From: Tim Townsend [REDACTED]
Sent: 11 February 2019 14:53
To: Andrew Wood
Subject: FW: LU/25/19/DOC - Highways response to DOC

From: Tim Townsend
Sent: 11 February 2019 14:37
To: Andrew Wood [REDACTED]
Subject: LU/25/19/DOC - Highways response to DOC

Project Name WINDROOS NURSERY, LITTLEHAMPTON			
Title PRELIMINARY S38 GENERAL ARRANGEMENT			
Project Phase PRELIMINARY			
Checked By SCW	Checked Date 27.10.15	Drawn By SCW	Drawn Date 27.10.15
Client Drawing No. -		Scale 1:500	(AT A1 SIZE)
PBA Drawing No. 063.5001.105			Revision C

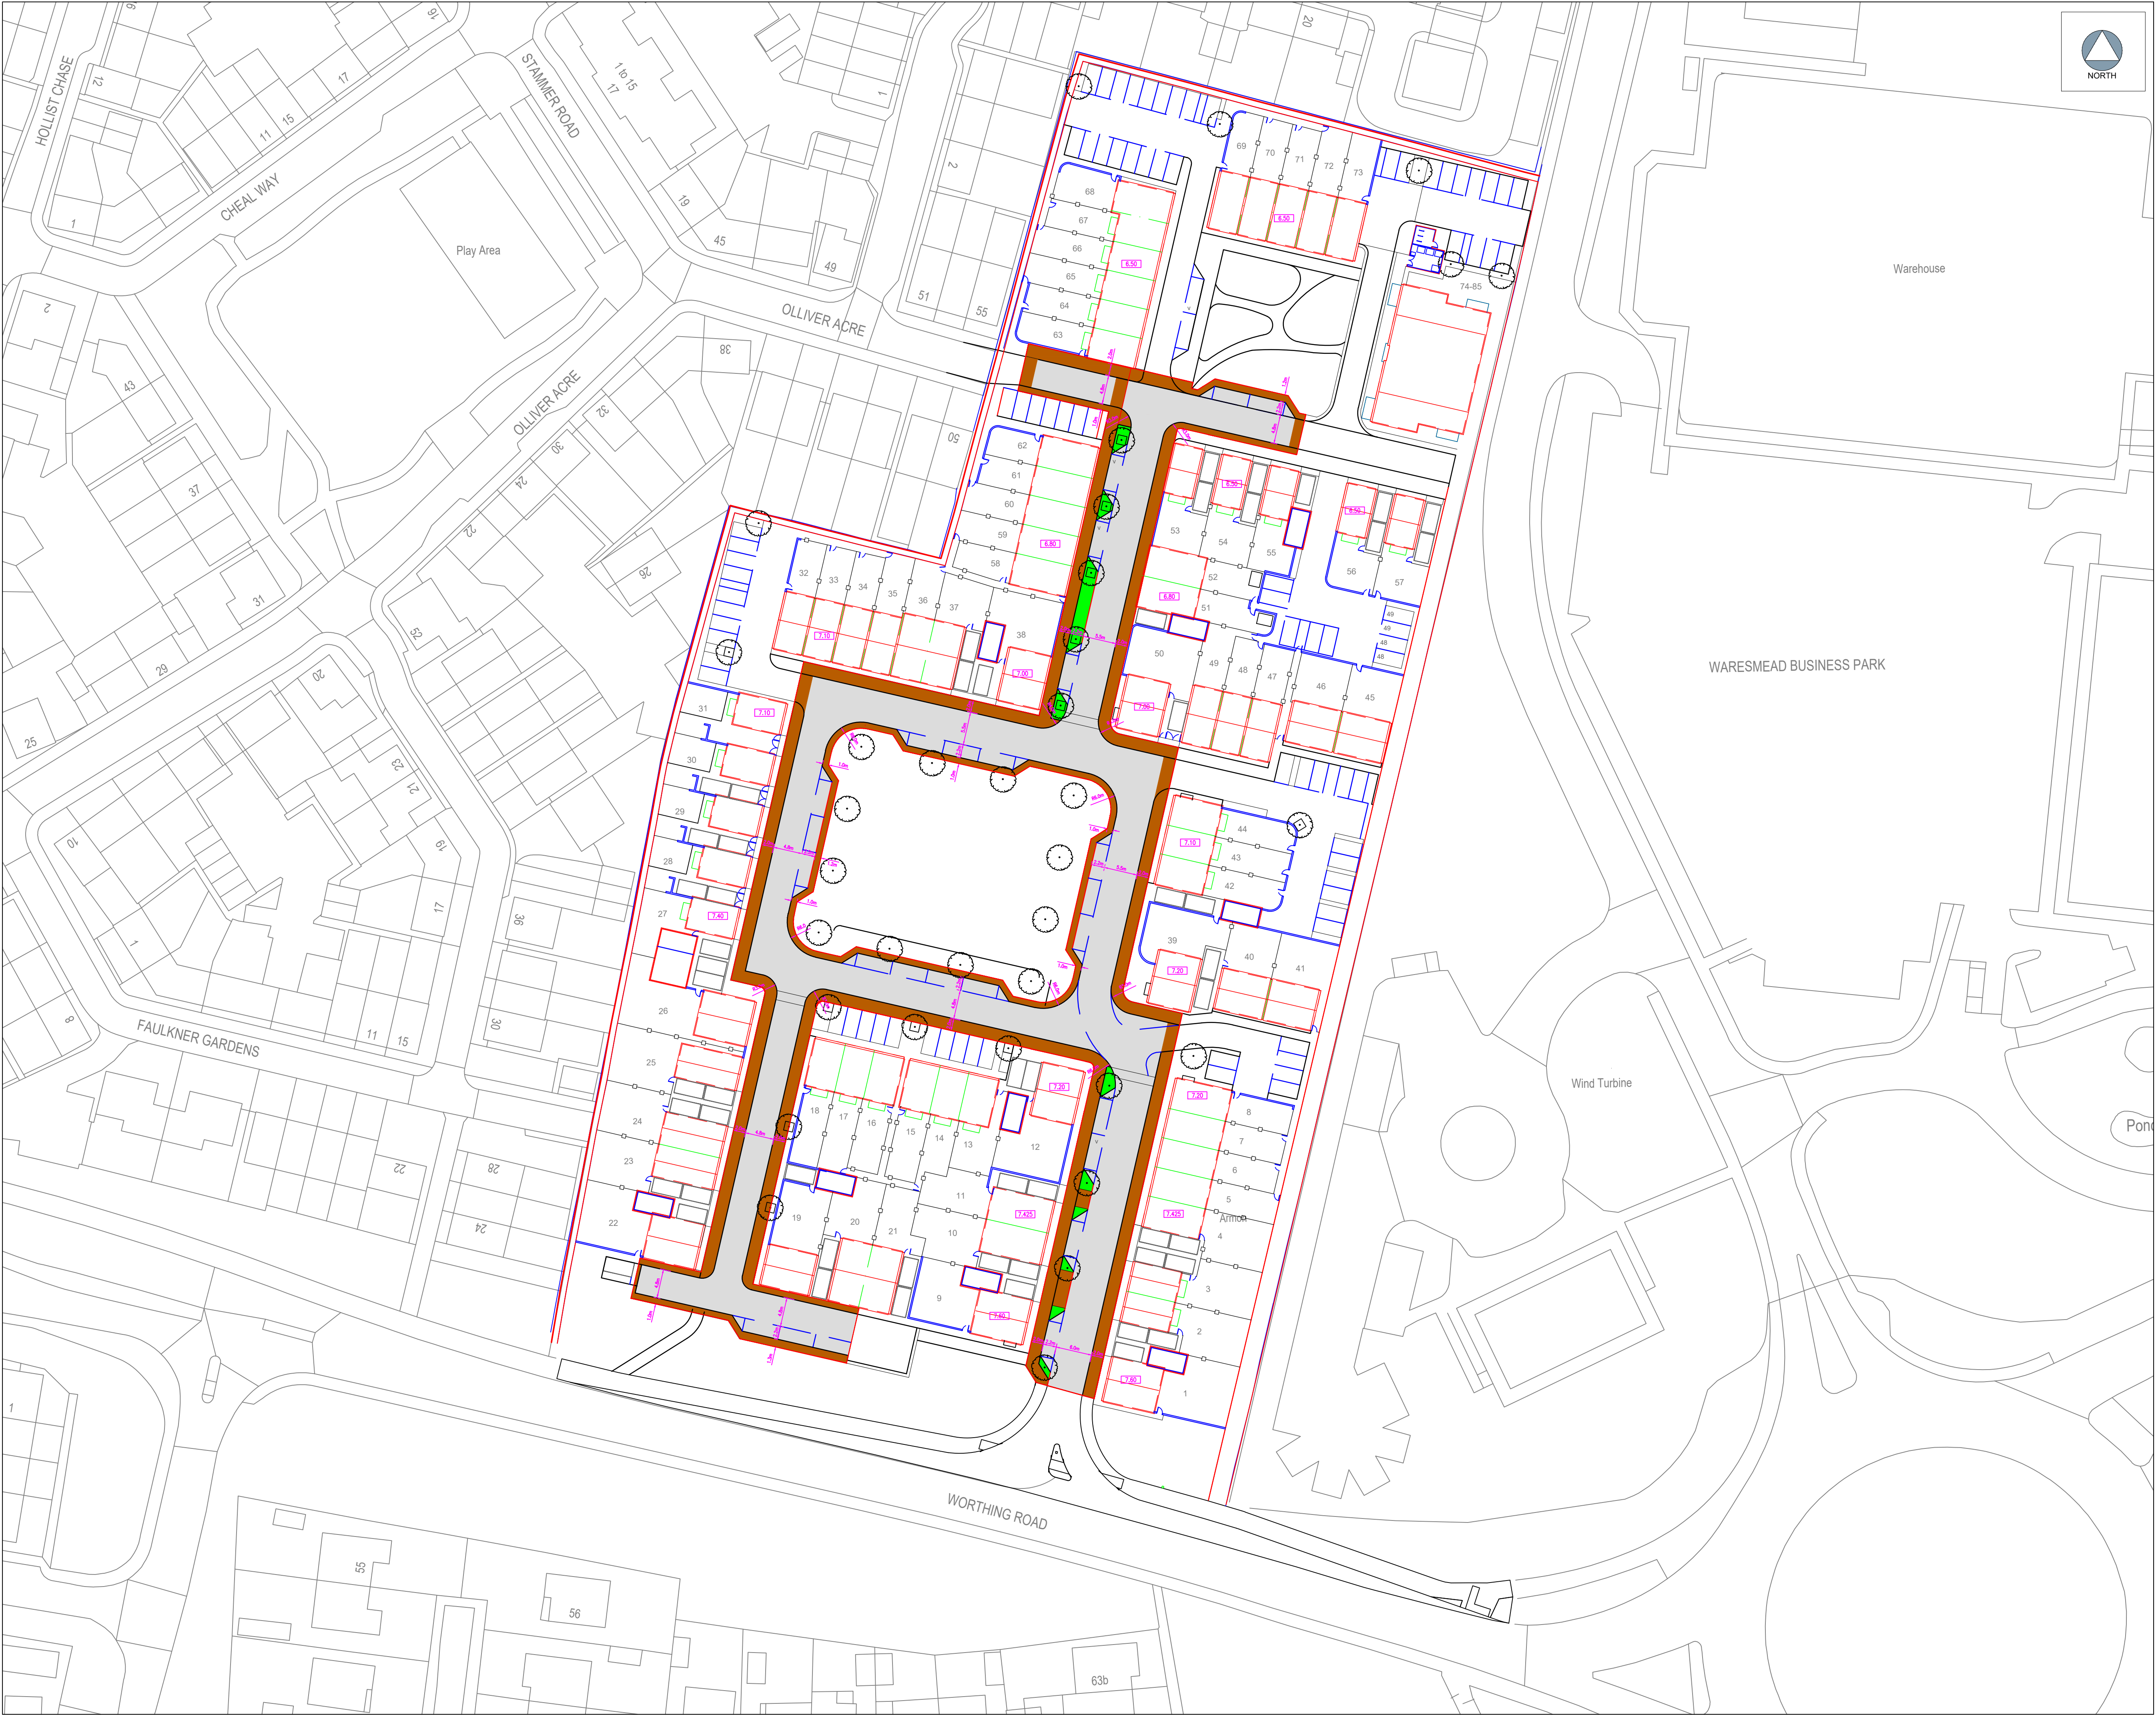
Further to the report I've just sent you, under the section about the plans marrying-up, the applicant should ensure that the WSCC scheme is the one they use alongside their development scheme (so all highways alterations as part of the A259 scheme - not just the footways). I just wanted to make that clear. It'd also be useful knowing their timescale - i.e. are they intending to start and finish before the A259 works commence or afterwards?
